Re. Modification Application and Report for the Boggabri Coal Mine - Increase in depth of mining (MP09_0182-Mod-8).

Garvin Burns
Executive Director
NSW Resources Regulator

19 September 2021

Figure 2 | Approved vs Amended Conceptual Final Landform

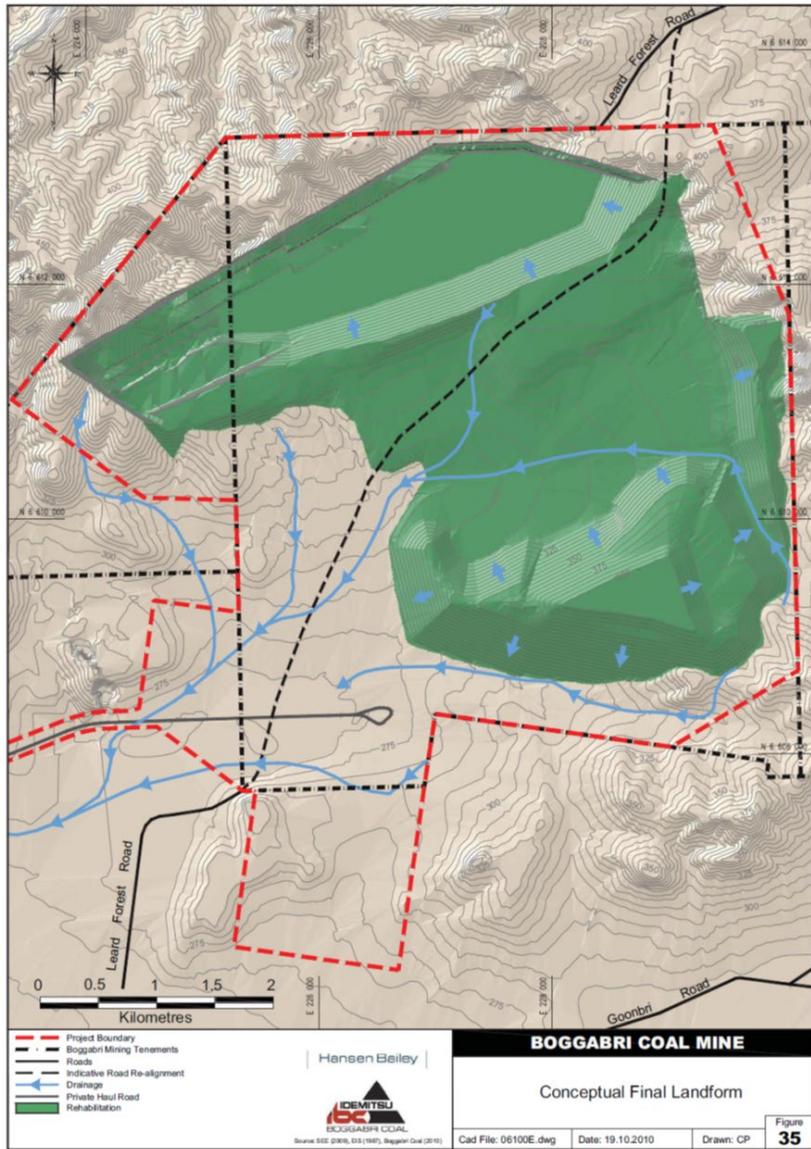
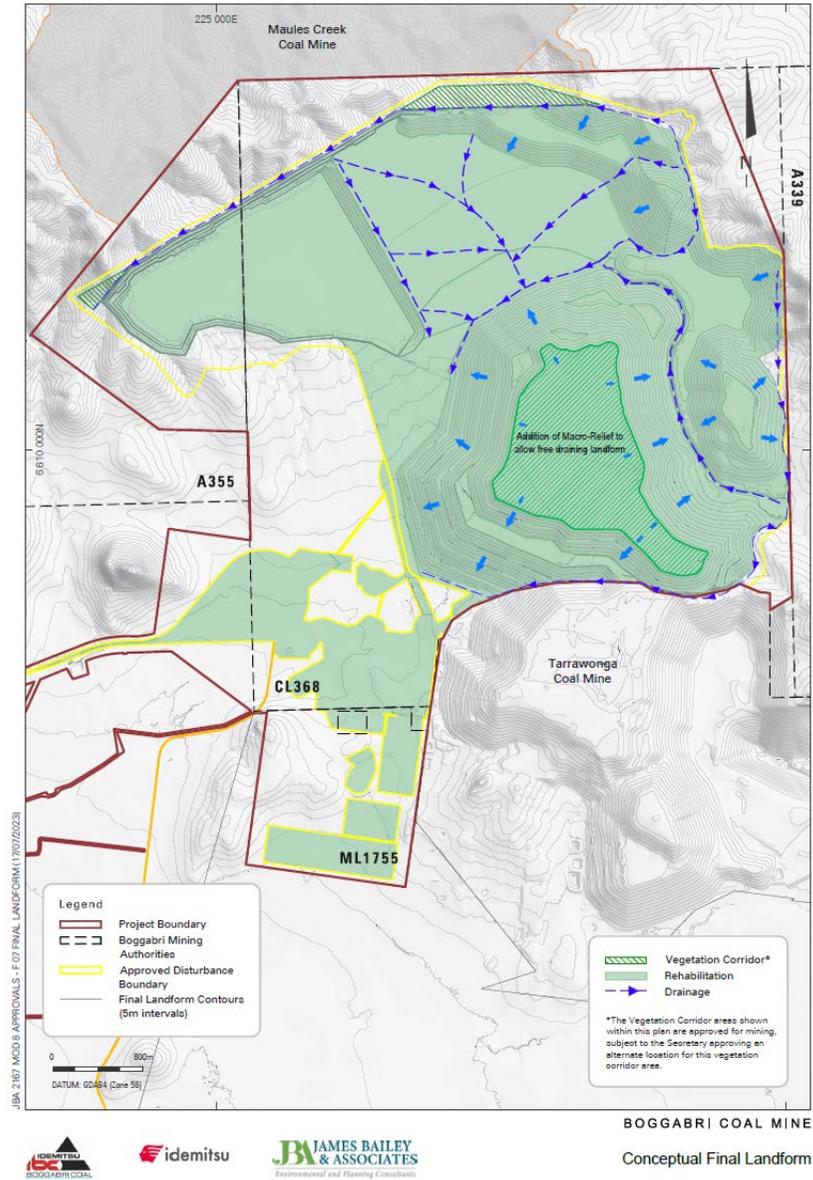
1. Figure 8 provided in the Modification Report and Figures 2 and 3 of Appendix M, do not provide an adequate level of detail for the Conceptual Final Landform plans (both visually and in text) and therefore are required to be updated to illustrate post-mining final land use(s) including vegetation boundaries and types, contours, drainage lines and domains for the entire site. This should be consistent with Figure 5.2 of the Rehabilitation Management Plan (April 2020).
